Date: 10/28/2021

Re: **Header Issue**
Location: Lot 12 Highland Grove (364 Windy Farm Dr. Fuquay-Varina, NC)
JDS Project No.: RDU2111572
Date of Inspection: 10/27/2021

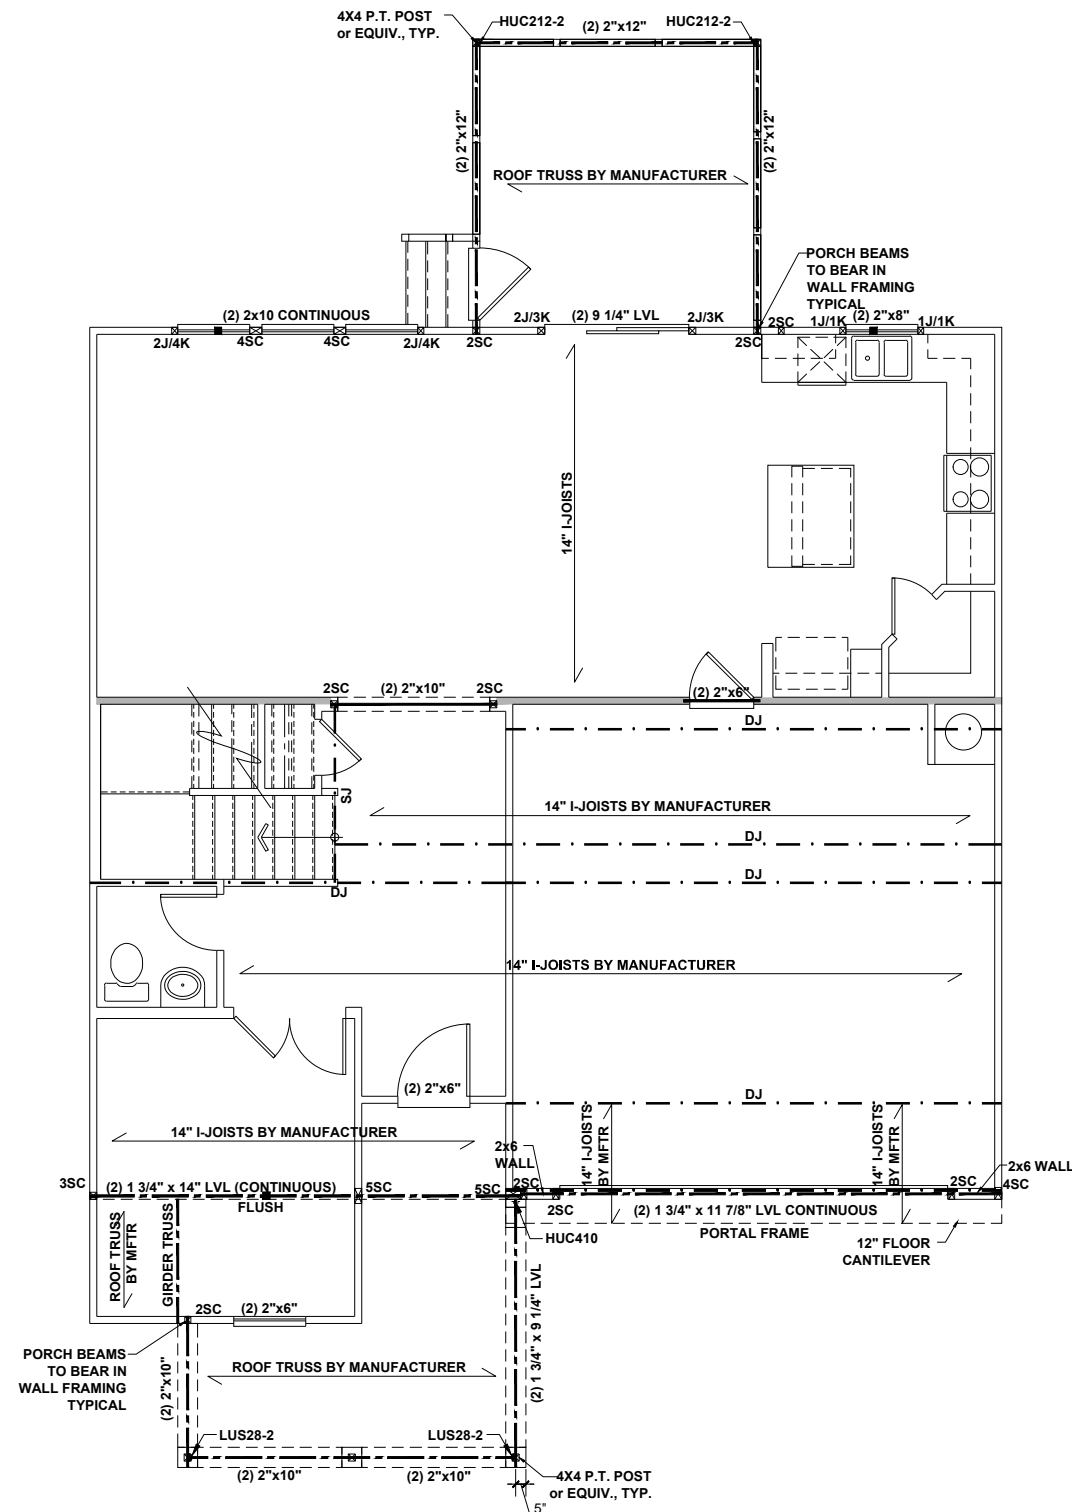
The client requested evaluation of the installed header framing at the triple window on the rear left side of the first floor. The plans show a continuous (2) 2x10 header. The installed header is spliced above each of the intermediate bearing points. The right most intermediate bearing point only has (1) jack stud on each side. The leftmost window has (2) Jack studs at each end. There are (4) king studs at each far left and right end of the three windows.

Based on our on-site observation and review the headers and Jack stud supports listed above are adequate to support the anticipated loading conditions. However, the triple opening is lacking King studs between the far left and center windows. The contractor should install solid blocking above the Jack studs between the left and center window. Then, install minimum of (2) vertical CS16 straps extending from the top plate, across the headers, and minimum 12" down (2) of the Jack studs below.
